From: [Airspace Protection](#)
To: [Jessica Fountain](#)
Cc: [Ania Dorocinska](#); [Lobegeier, Jain](#)
Subject: CASA Comments Regarding the Notice of Exhibition for Baiada Oakburn Poultry Processing Plant (SSD-9394) [SEC=UNCLASSIFIED]
Date: Tuesday, 20 August 2019 12:24:00 PM
Attachments: [image002.png](#)
[image003.png](#)
[image004.png](#)
[image005.png](#)

CASA has reviewed Section 3.2, Section 3.3.1 and Section 4.18 of the Environmental Impact Statement.

**OAKBURN PROCESSING PLANT
SITE PLAN - Lot 100 DP1097471**

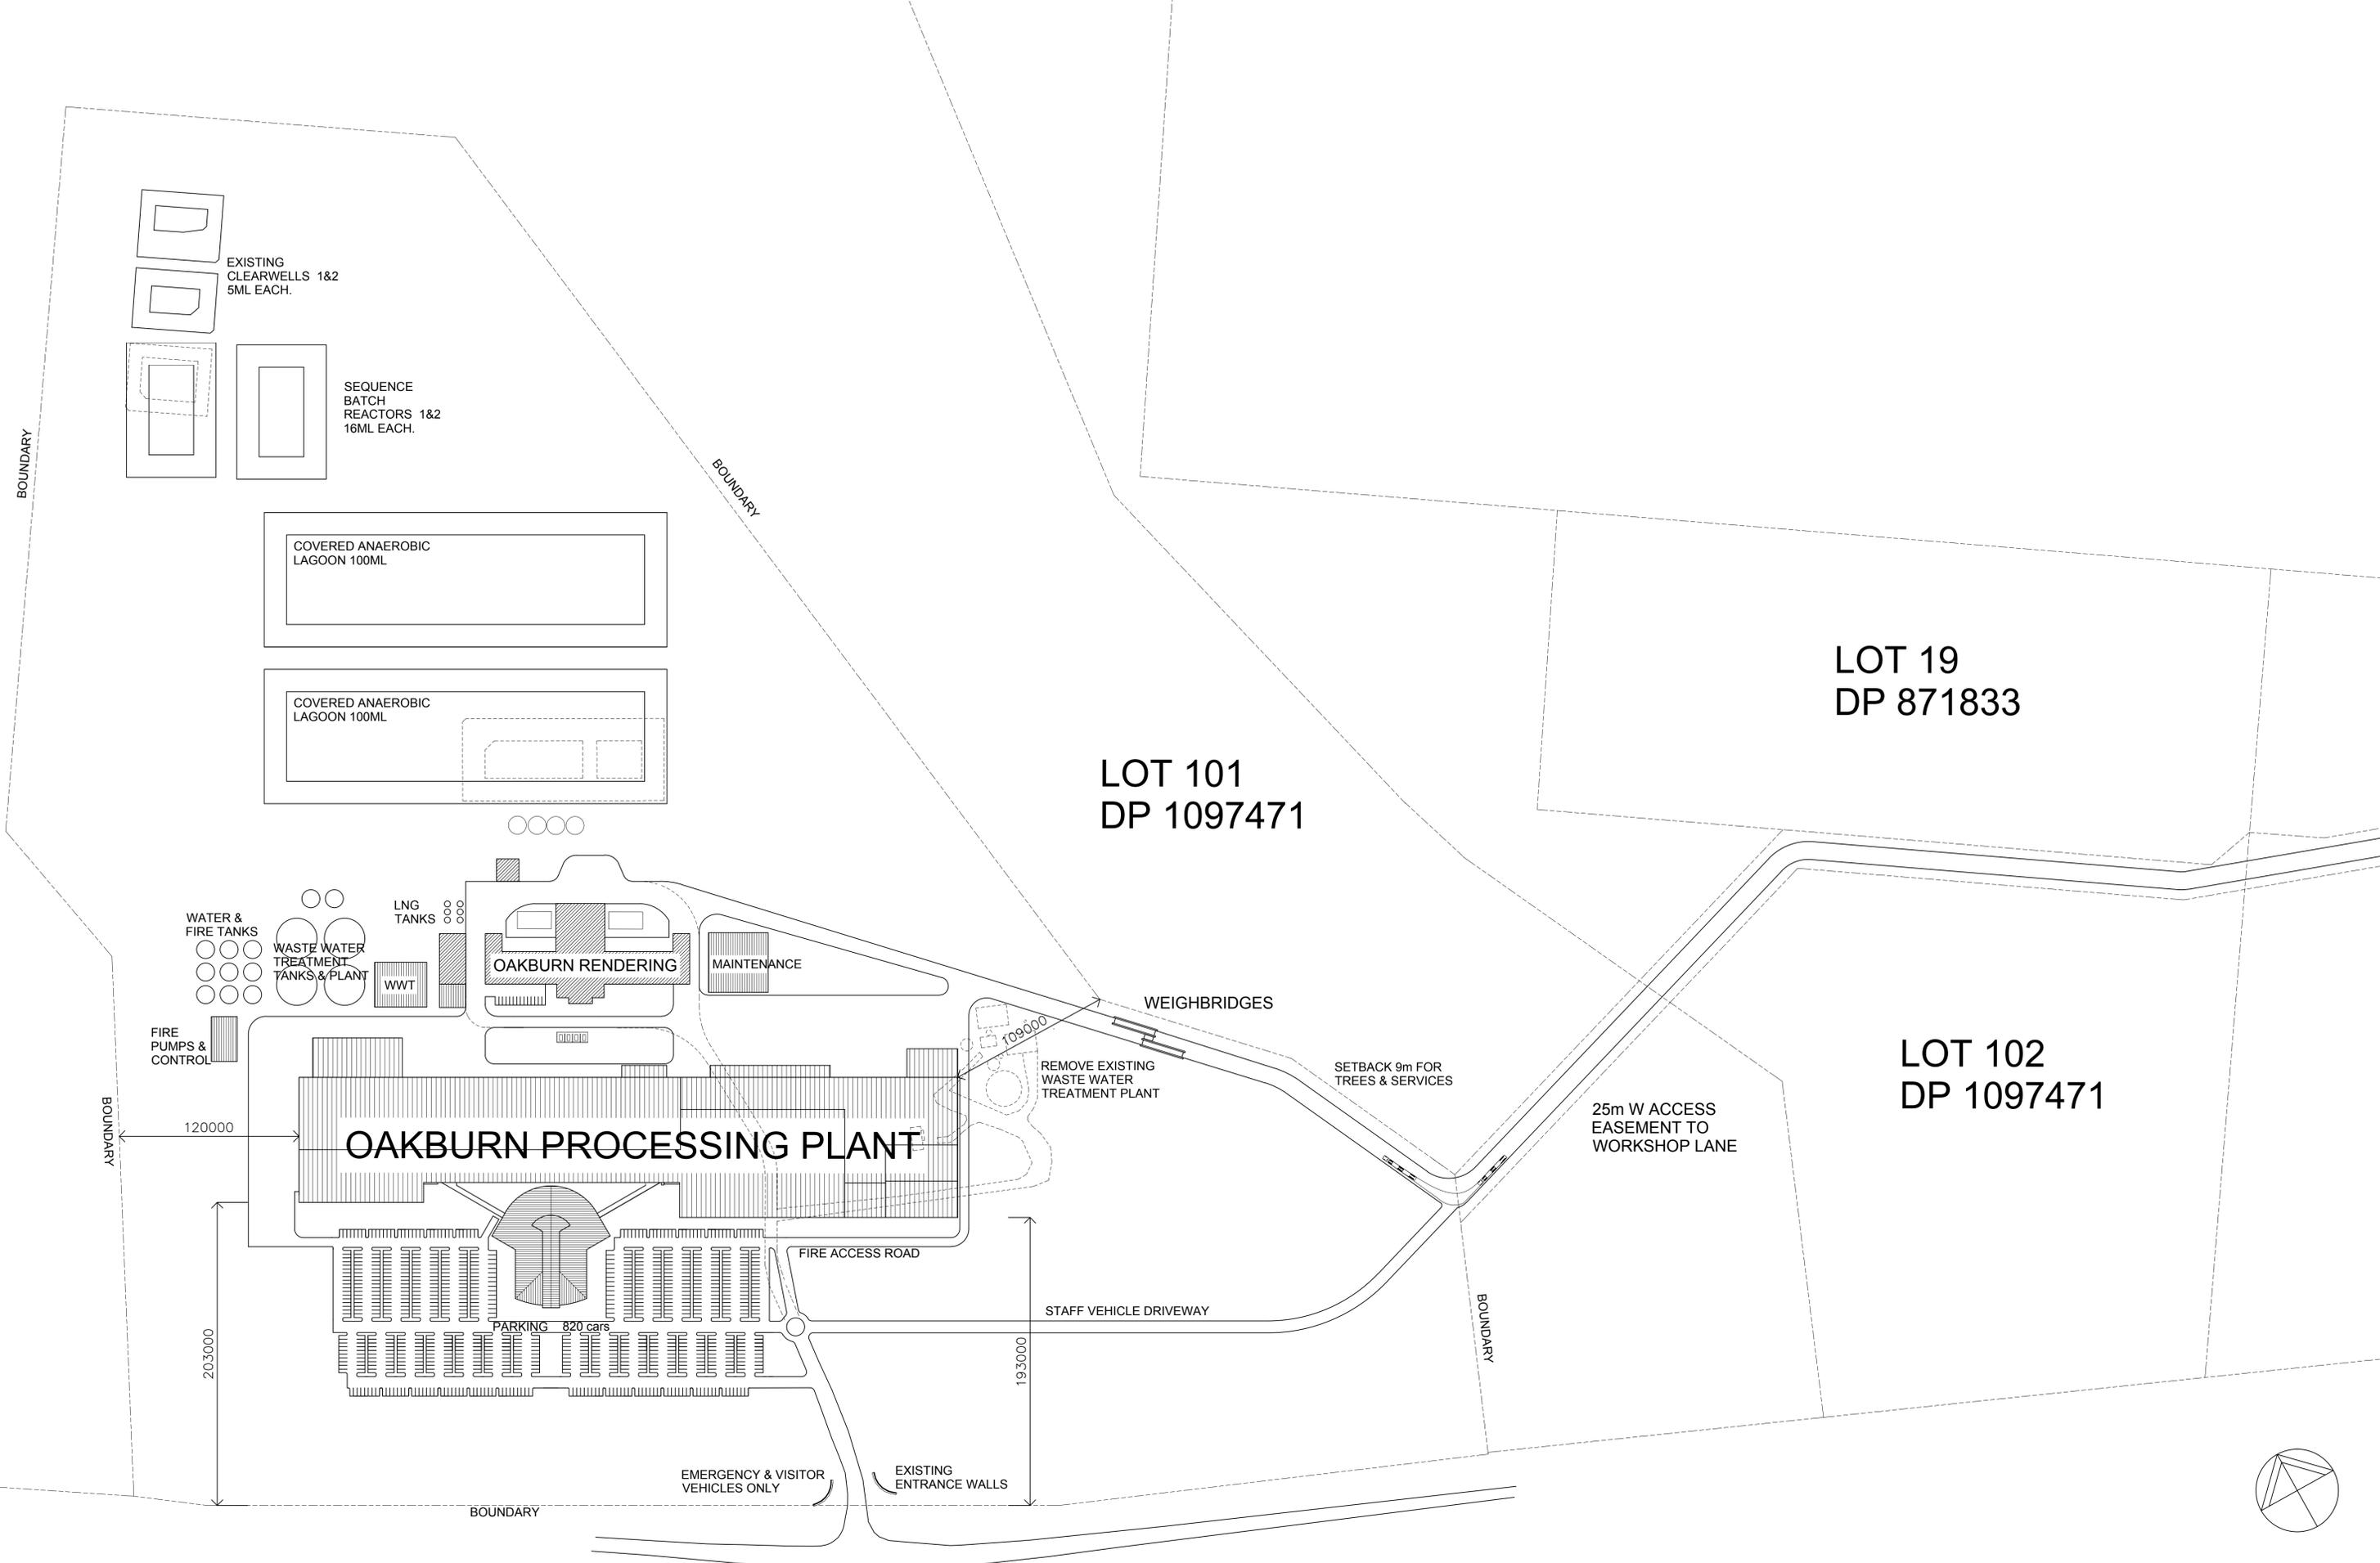
Guideline B – Managing the Risk of Building Generated Windshear and Turbulence at Airports. The Site Plan shows that the Processing Plant is approximately 310m from the centreline of Runway 12L/32R. The EIS assessment refers to the Obstacle Limitation Surfaces and concludes that no buildings which would create unsafe windshear or turbulence impacts are proposed. The conclusion is erroneous as the criteria in Guideline B are independent of the Obstacle Limitation Surfaces. Buildings that are under the OLS can cause wind effects (as described in Guideline B para 88). The Guideline B wind effects assessment criteria are the 1:35 rule (paras 15 and 54) and the rectangular ‘assessment trigger area’ (para 49). It is noted that a Wind Rose was provided in the EIS and the prevailing winds are from the South East.
